From: Sarah Burrow <Sarah.Burrow@arun.gov.uk>
Sent: 27 May 2021 10:51
To: Planning.Responses <Planning.Responses@arun.gov.uk>
Cc: Kathryn Welch <Kathryn.Welch@arun.gov.uk>
Subject: RE: Planning Consultation on: WA/41/21/DOC

Engineers Comments Regarding Surface Water Drainage

Application No: WA/41/21/DOC
Registered: 13th May 2021
Site Address: Ross Cottage Eastergate Lane Walberton BN18 0BA
Description of Works: Approval of details reserved by condition imposed under ref WA/78/20/HH relating to Condition No 3 - surface water drainage.

Detailed Drainage Layout Scale 1:250

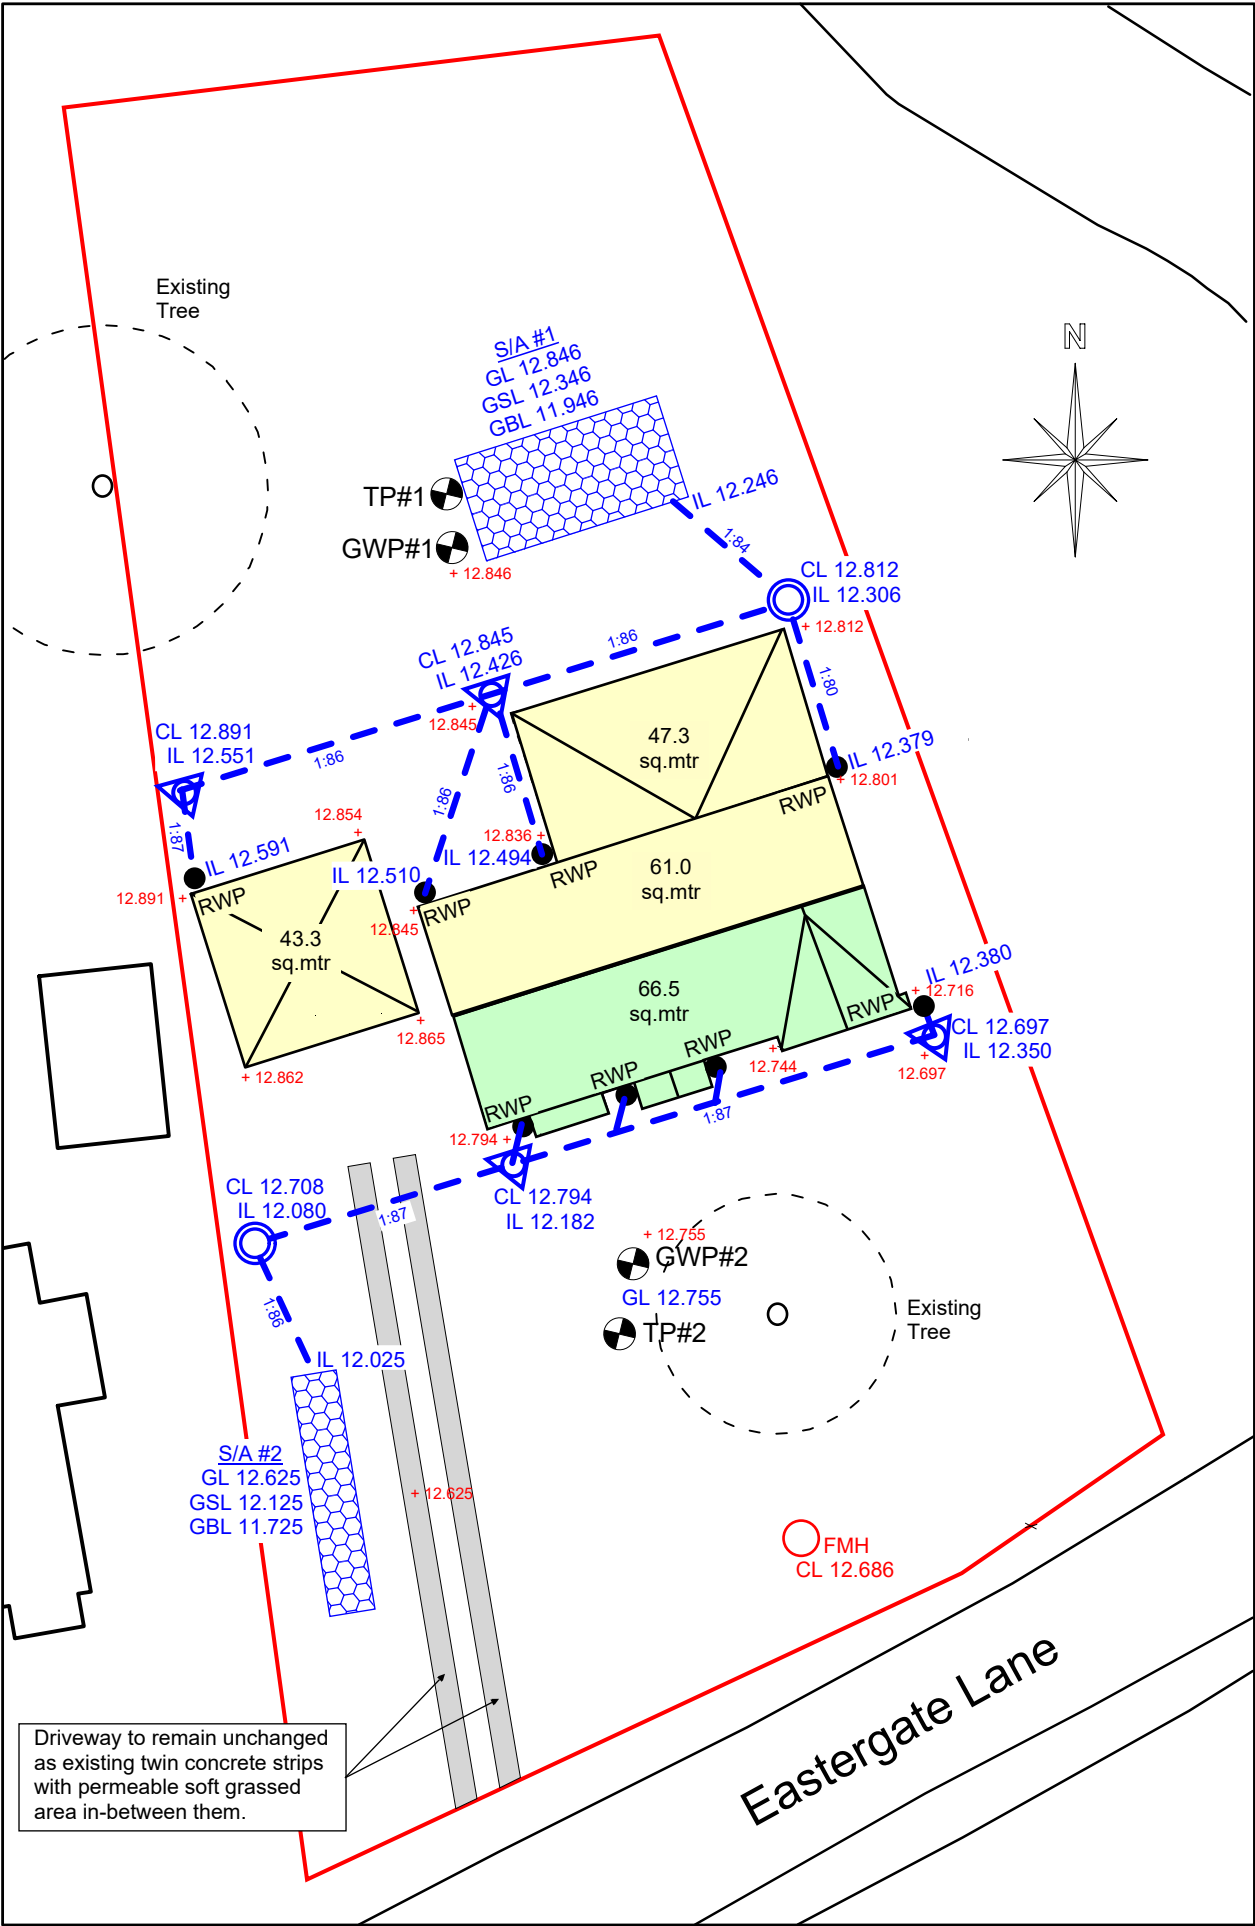
I am satisfied with the sizing of the soakaways and the construction details that have been supplied. However, can the applicant confirm that the soakaway in the front garden is located a minimum of 2.5m from the property boundary? If this is not the case, please reposition this soakaway to meet this requirement. Once this point has been clarified/rectified then I intend to recommend discharge of the condition.
